Application Reference: 2026/0187

Site Address: 8 Woodside View, Bolton Upon Dearne, Rotherham, S63 8GZ

Introduction: This application seeks full planning permission for raising of roof to enable a loft conversion with raising of the ridge and dormer loft extension towards the rear.

Project	8 Woodside View, S63 8GZ
Client	Miss Yearsley
Title	Proposed Elevations
Number	26004-DR-A-2003
Scale	1 : 100@A3
Revision	A
Description	Updated due to planning comments
Stage	Planning
Drawn	TD
Date	21.04.2026

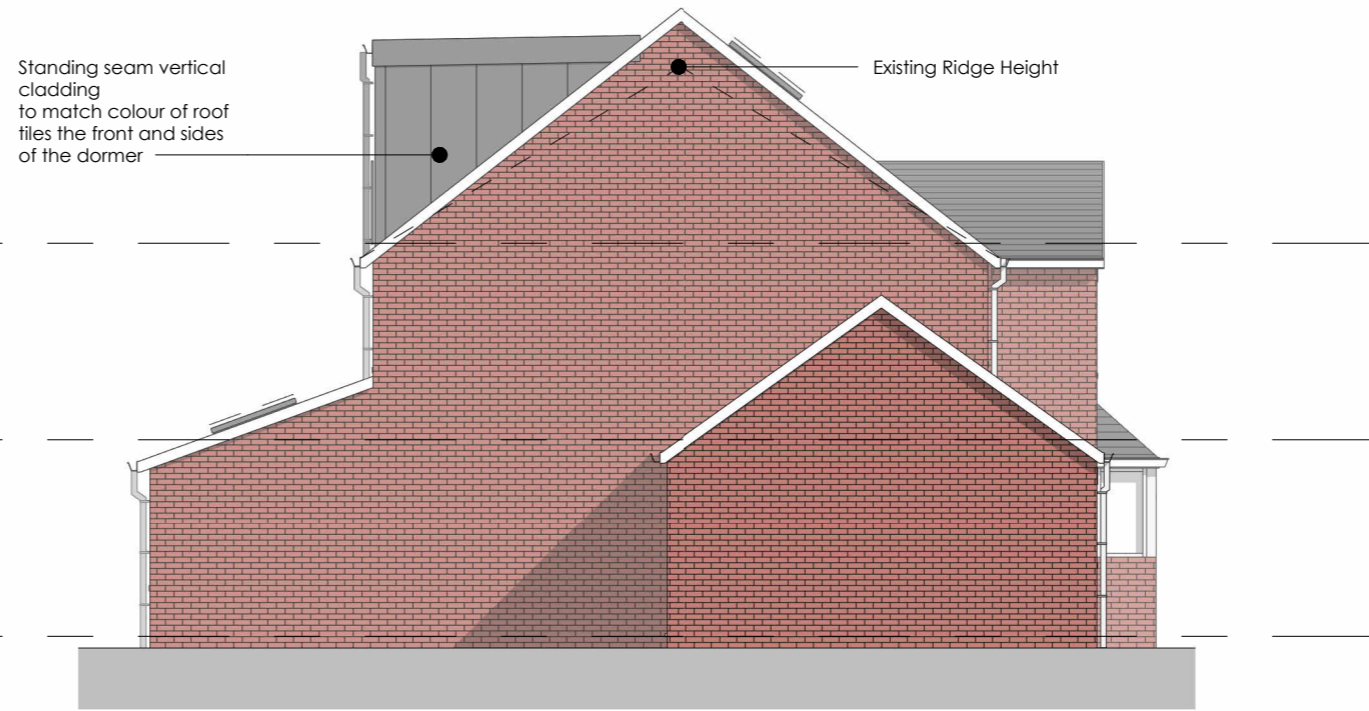
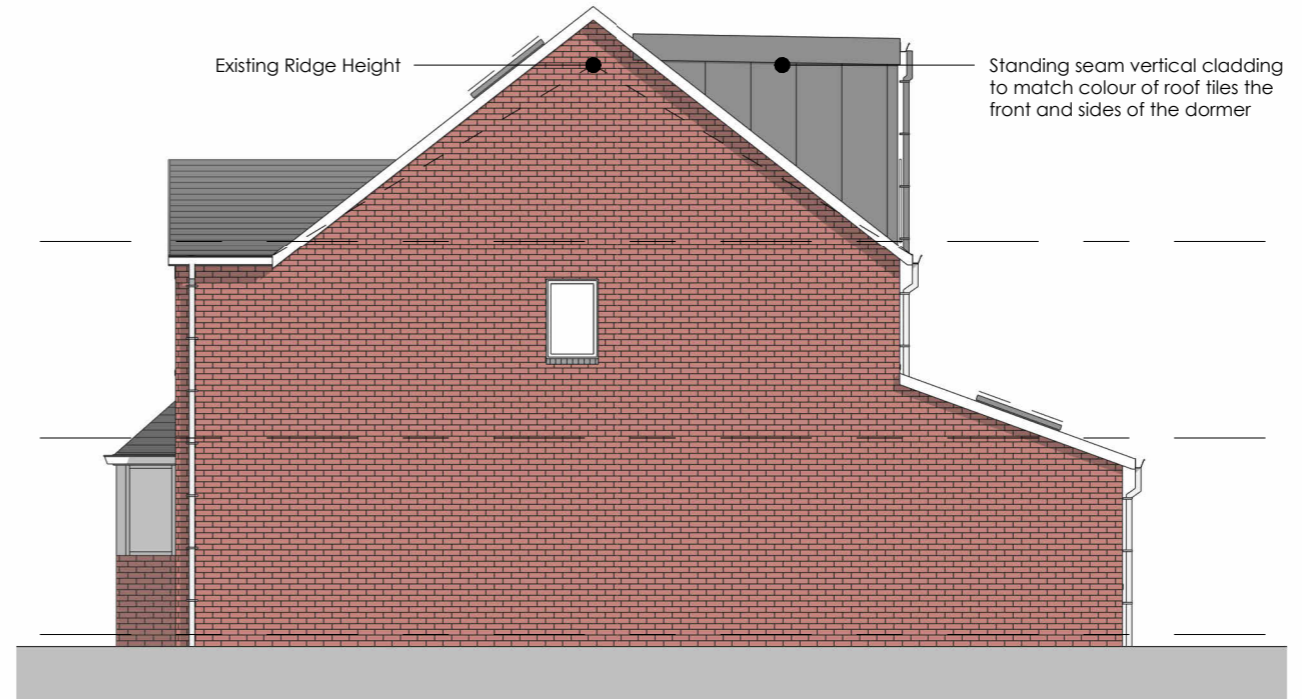
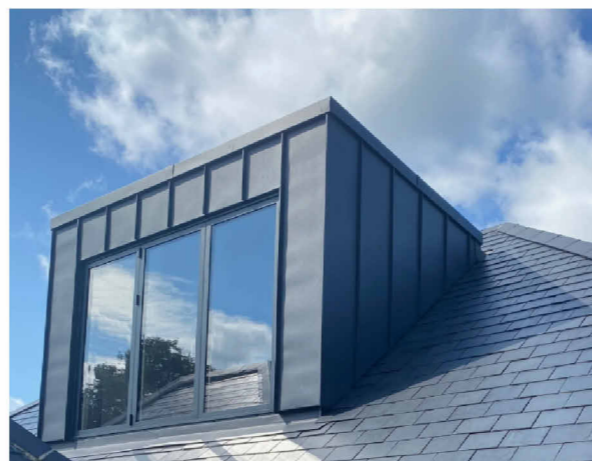
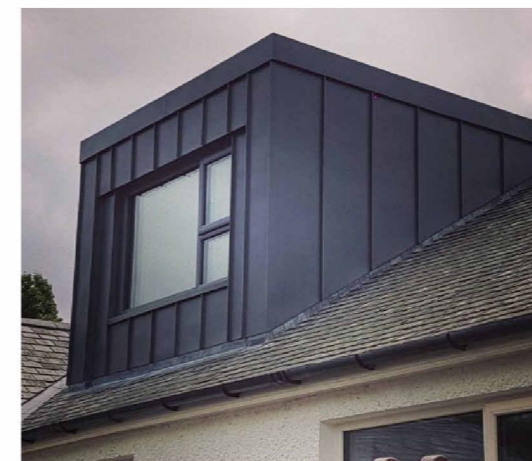
With a proposal which includes raising the height of the main roof by approximately 79cm (0.79M), as visible on the front elevation, given the above, the increased height of the proposal would not have a significant impact on the character of the dwelling or on the street scene. Whilst there would be some deviation in alignment of roof lines, this is not considered to be significant.

The side elevation of the proposal, due to the rear dormer being partially visible would have a more noticeable impact upon the design and scale of the dwelling, than increase in height and inclusion of roof lights on the front elevation. For the side elevation, although there is a wider gap between the application dwelling and No6, than spacing between most houses in the street, the dormer whilst visible would not be overtly visible, and the proposed materials would be in a colour to match the existing roof. The dwelling and subsequently the side dormer is located much closer to No10., so would be less visually prominent or impactful.

On the rear elevation, the proposed rear dormer would have an impact on the scale and appearance of the dwelling. However, in mitigation, the rear elevation and consequently the proposed dormer, it would only be partially visible from nearby neighbouring rear gardens and would not be visible from the principal street scene. Due to the location of the dwelling, and open agricultural fields to the rear of the dwelling and broader street, there would be no wider visual impact from the proposed dormer and heightened rear elevation.

In more detail about the dormer, whilst materials of a similar appearance are proposed to be used, this specially relates to the colour (which has been confirmed via amended plans), which would

match the main roof rather than matching tiles as advised in the SPD House Extensions and Other Domestic Extensions. Equally, the proposed dormer would not be of the preferred pitched roof style, but instead a flat roofed box dormer.

During the processing of the application, confirmation of materials was requested and provided by the applicant's representative in an annotated plan with image examples of proposed materials.
